CITY OF ALBUQUERQUE

**Re: Interwest Safety Supply, 5821 Coronado Avenue NE,
Traffic Circulation Layout
Architect's Stamp dated 11-12-08 (D18-D053)**

Re: Interwest Safety Supply Shed, Grading and Drainage Plan
Engineer's Stamp dated 8-15-07 (D18/D053)

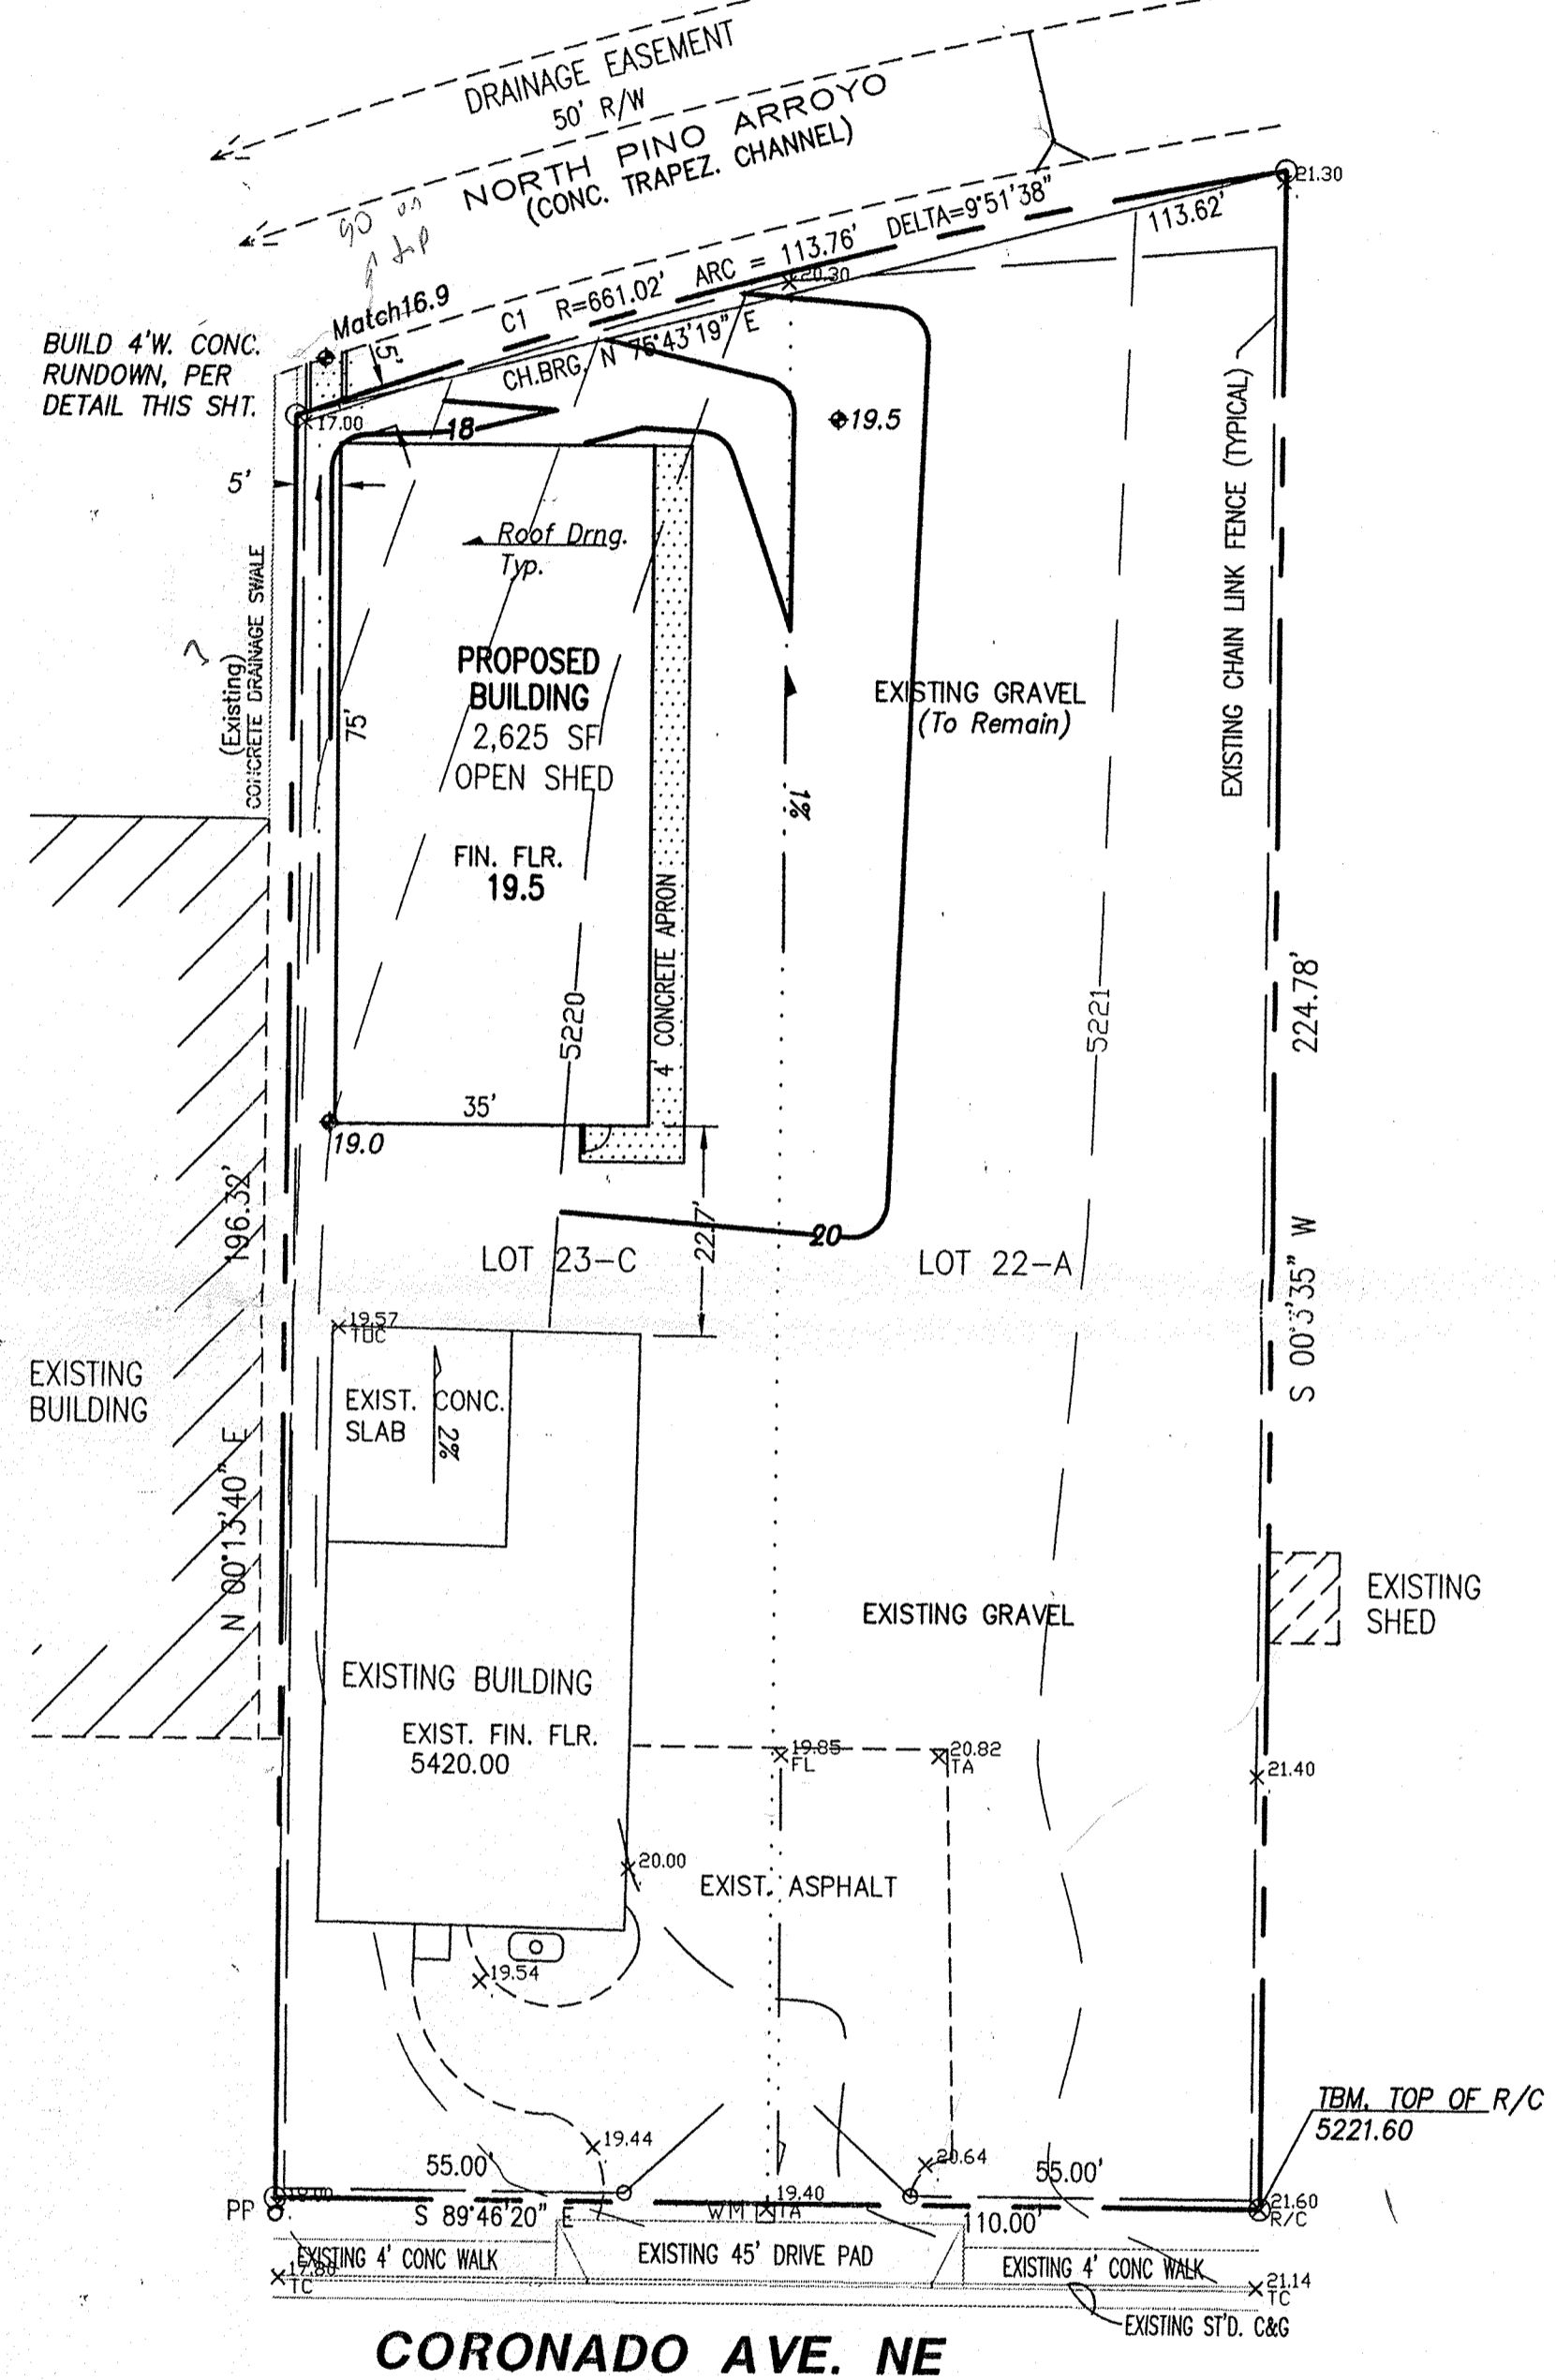
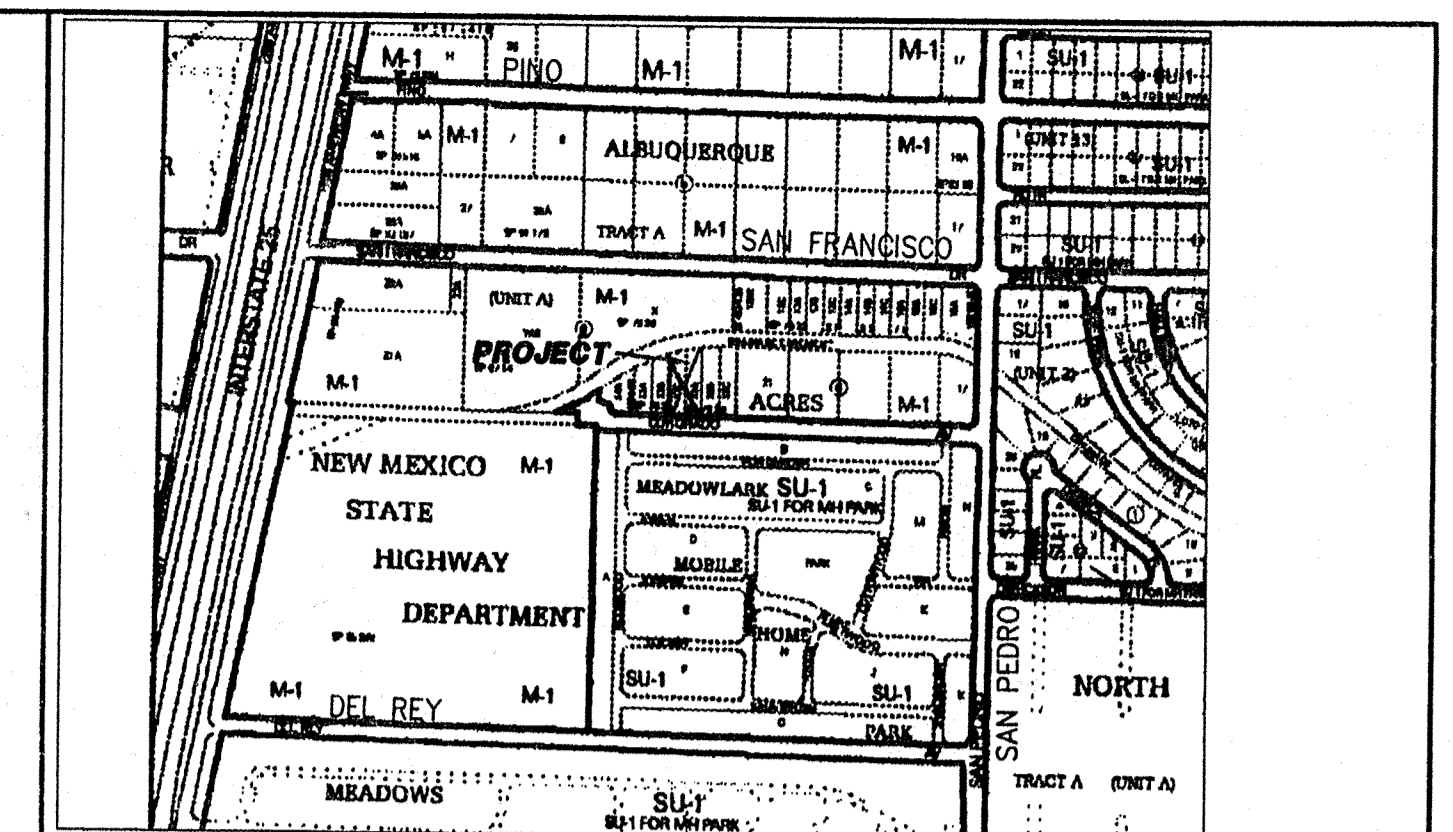
- The concrete rundown to the channel should be built on top of and be connected to the channel, rather than abut it. Provide a detail with inverts.
